From: planning
Subject: FW: Consultation on planning application 3/2017/0699 land at Leagram Hall, Leagram Park, off Burtholme Lane, Chipping PR3 2RD
Attachments: 17 0699 Consult.pdf

I am writing on behalf of the Bowland with Leagram Parish Council with regard to the planning application no. 3/2017/0699.

The application is for the installation of a 21m high mobile telecommunications mast and associated equipment cabinets located in field to the west of Leagram Hall.

Drawing Title: PROPOSED SITE PLAN

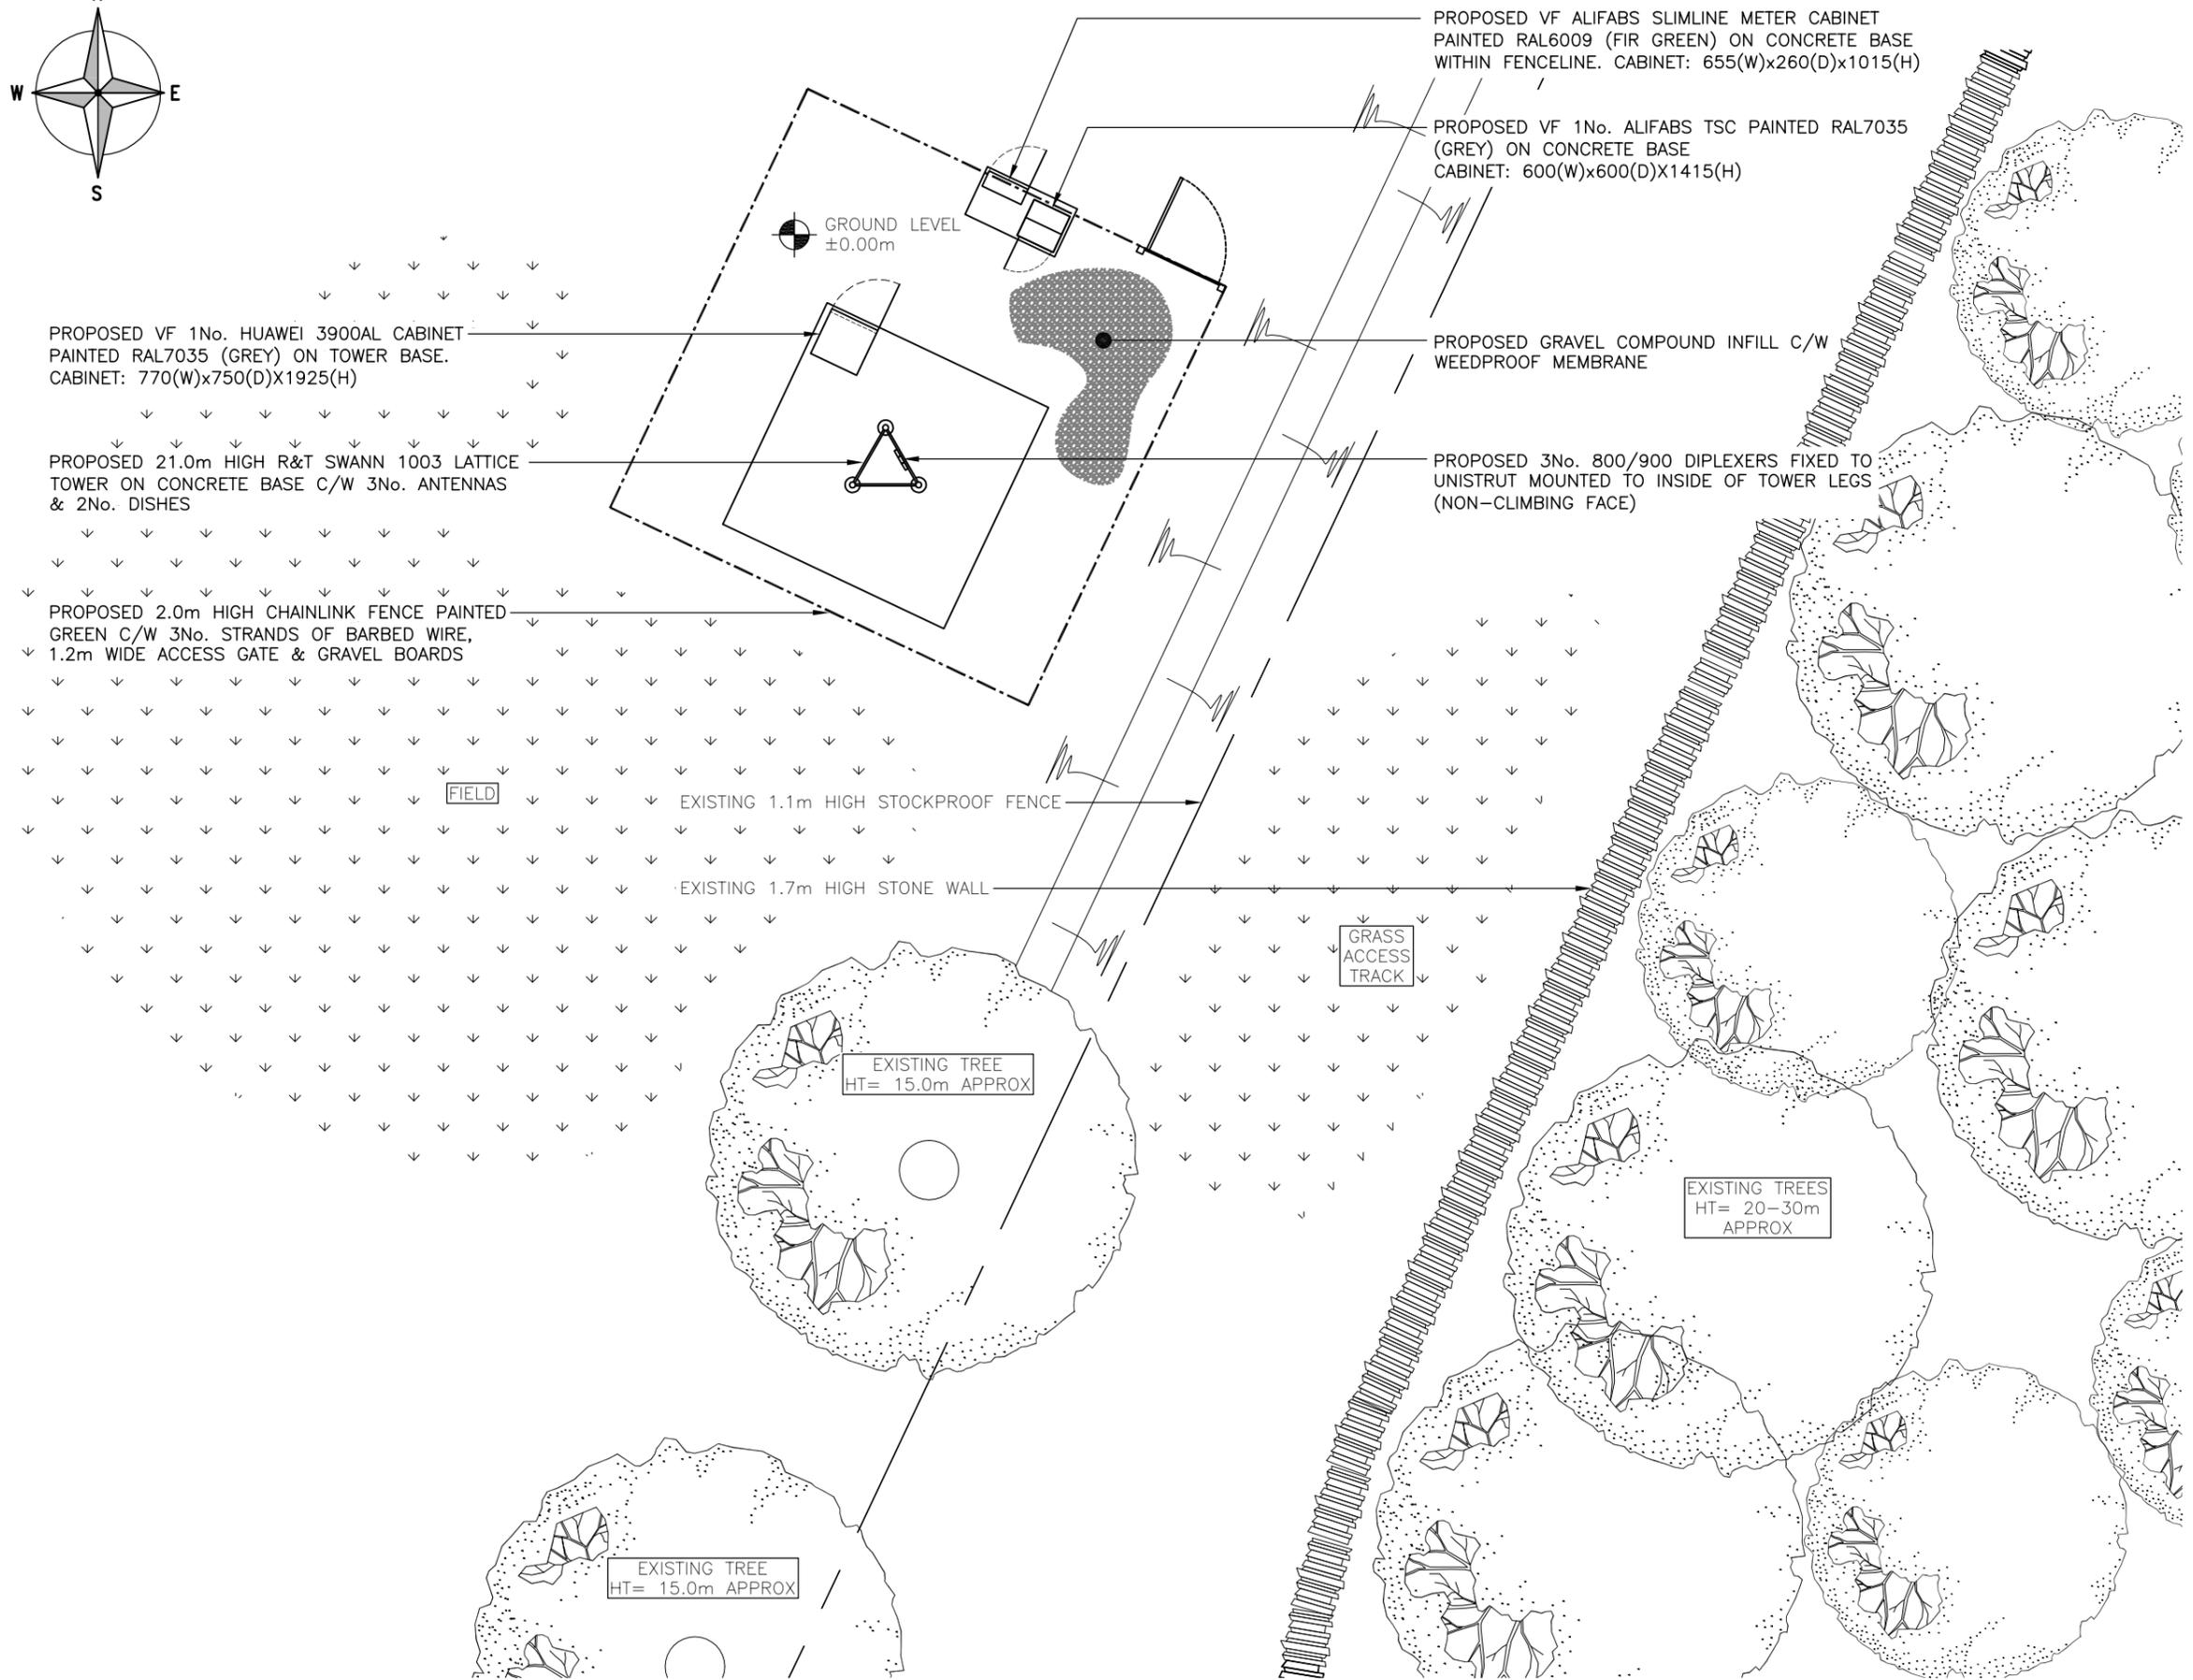
- The access to the site is presently inaccessible, however the plans do not show how this would be addressed. Clarification would be appreciated.
- As the proposed mast is 21 metres high, it is very difficult to envisage how much taller than the existing trees would be visible from some angles. The photographs provided do nothing to help this and it is only if a complete picture of the mast in situ is made available would it become very clear that this is a significant structure quite at odds with its surroundings.

Drawing Title: PROPOSED SITE ELEVATION

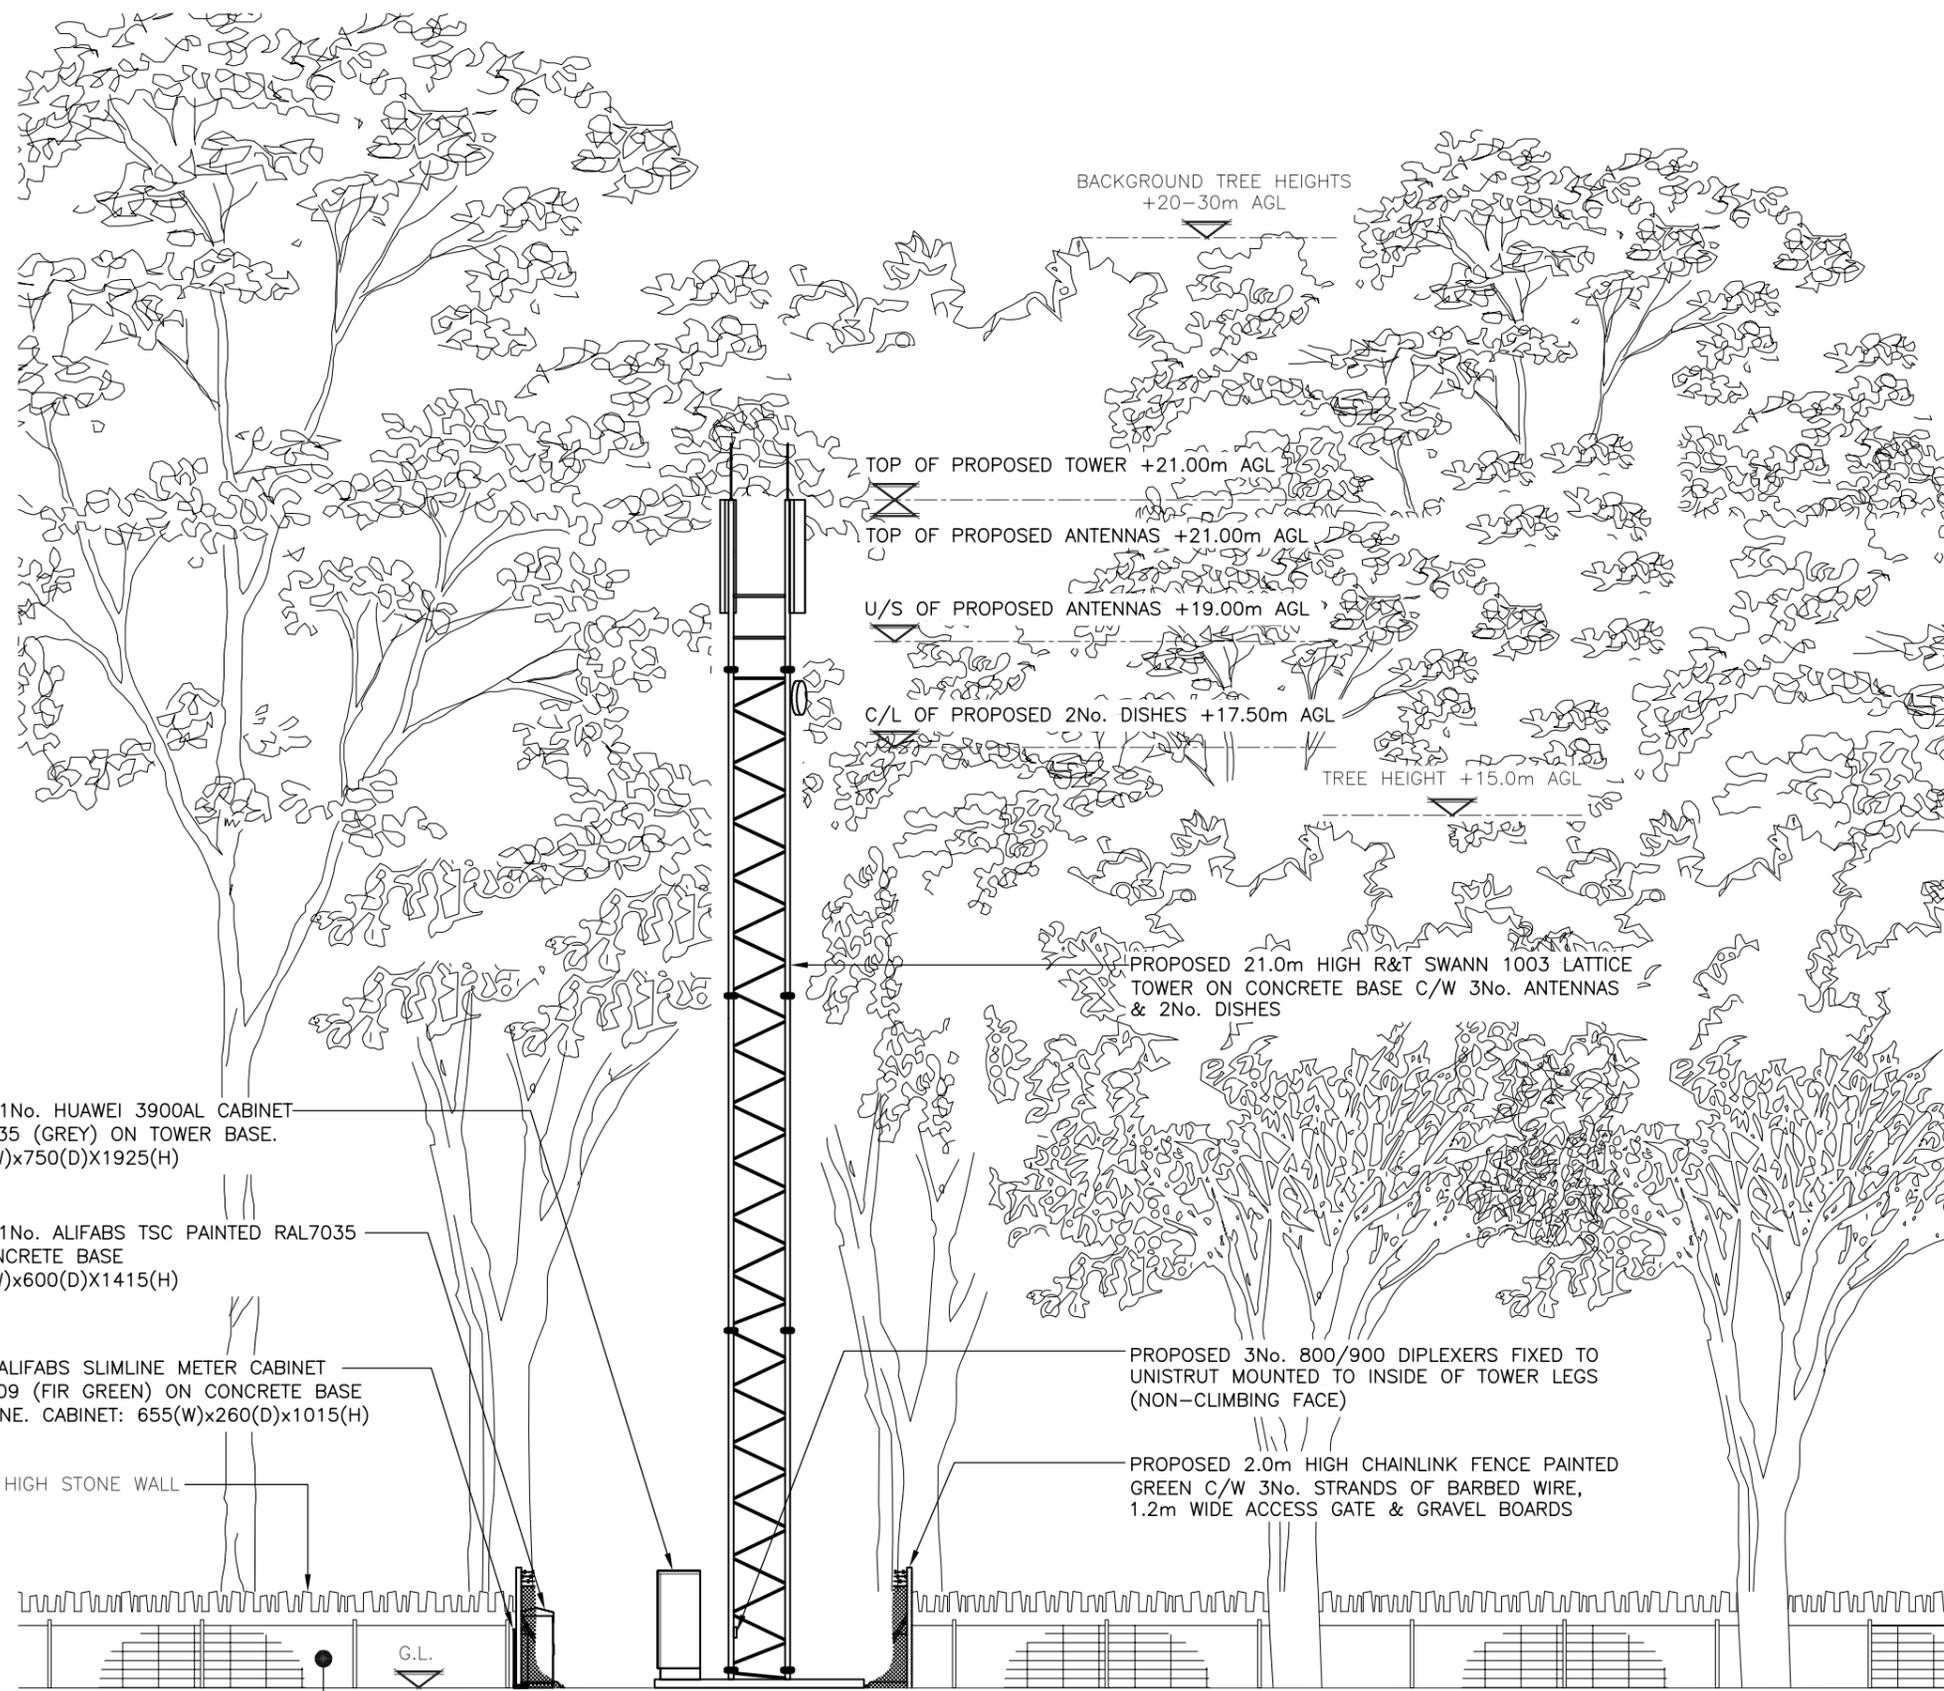
- The visual impact from the North, South and West of the site would, however be significant. There were strong objections to the proposal for this reason.
